Stonestreet Green Solar

Illustrative Project Drawings - Not for Approval

PINS Ref: EN010135
Doc Ref. 2.6(B)
Version 3
Deadline 3
January 2025

2.6(B) Illustrative Project Drawings – Not for Approval

Drawing Title:  
**Illustrative Layout Plan  
 Sheet 1 of 5**

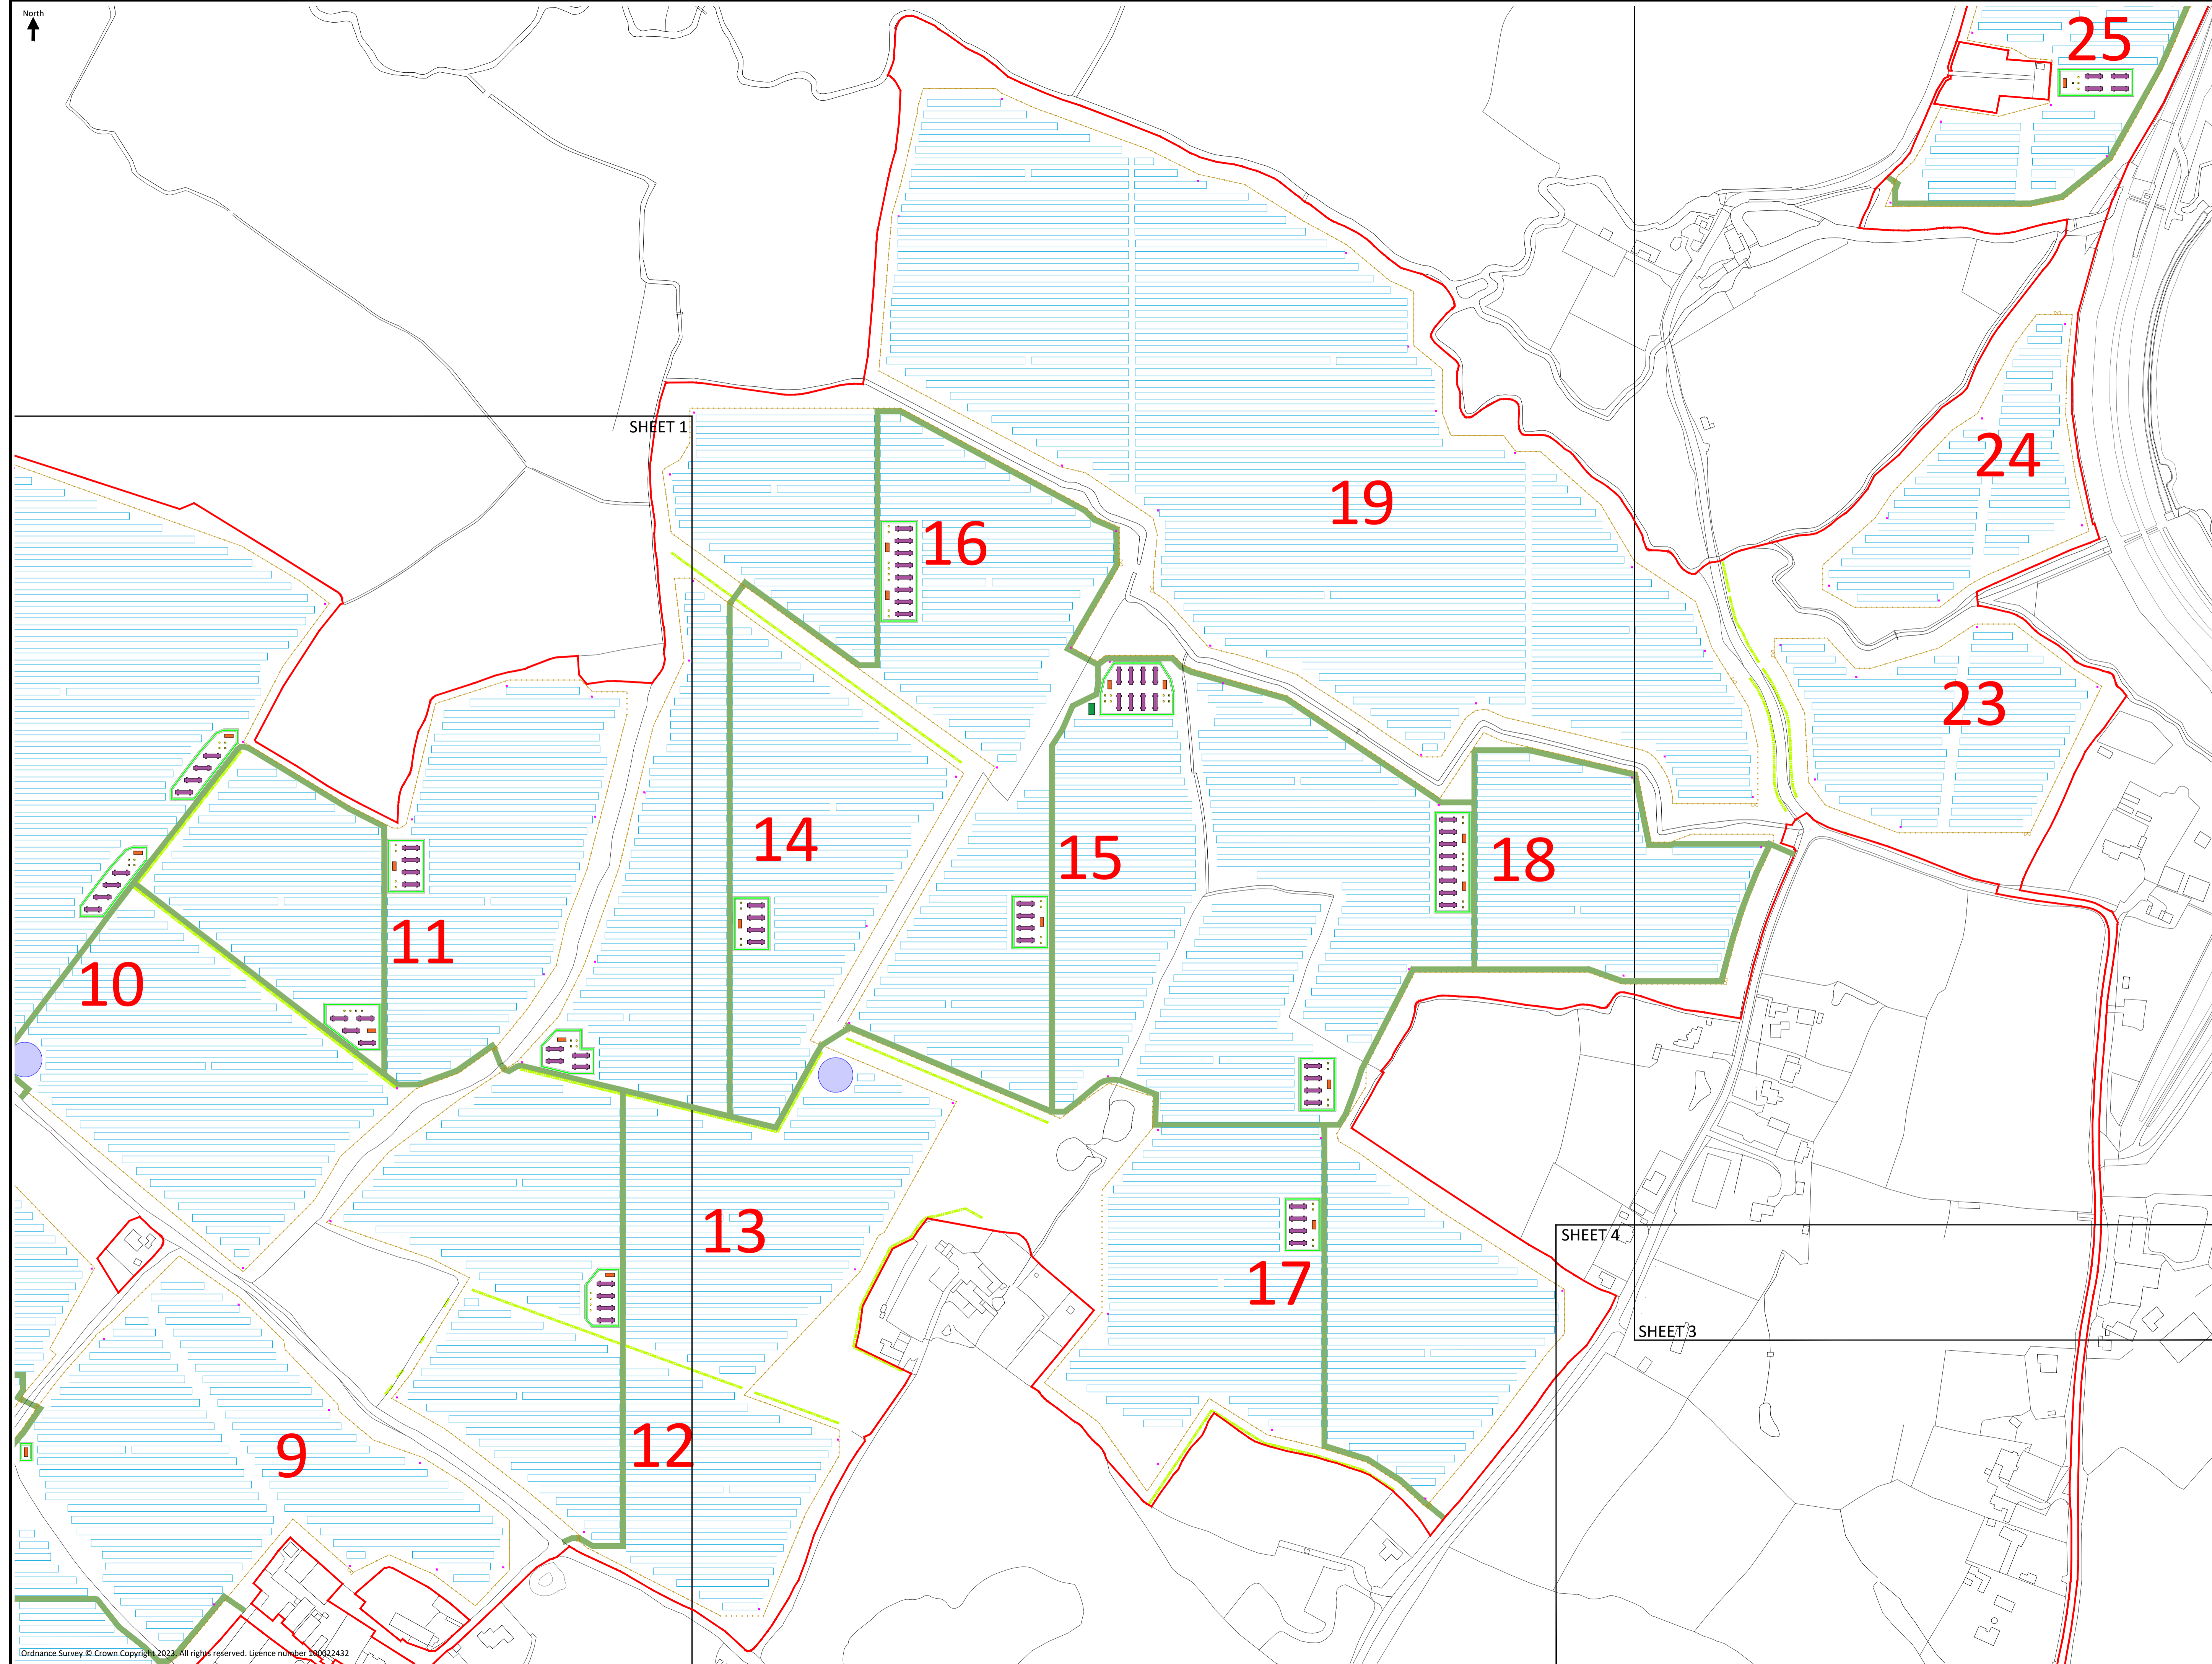
Drawing Number	Revision	Drawing Title	Reason for Revision	Scale
142-01-01	01	Site Location Plan	No change made	1:7,500 @ A1
142-02-01	03	Illustrative Layout Plan - Key Plan	Updated revision no. and date.	1:7,500 @ A1
142-02-01-pg1	03	Illustrative Layout Plan Sheet 1 of 5	Updated to reflect revision in the approach to skylark mitigation, as discussed with Kent County Council	1:2,000 @ A1
142-02-01-pg2	03	Illustrative Layout Plan Sheet 2 of 5	Updated to reflect revision in the approach to skylark mitigation, as discussed with Kent County Council	1:2,000 @ A1
142-02-01-pg3	03	Illustrative Layout Plan Sheet 3 of 5	Updated to reflect revision in the approach to skylark mitigation, as discussed with Kent County Council	1:2,000 @ A1
142-02-01-pg4	03	Illustrative Layout Plan Sheet 4 of 5	Updated to reflect revision in the approach to skylark mitigation, as discussed with Kent County Council	1:2,000 @ A1
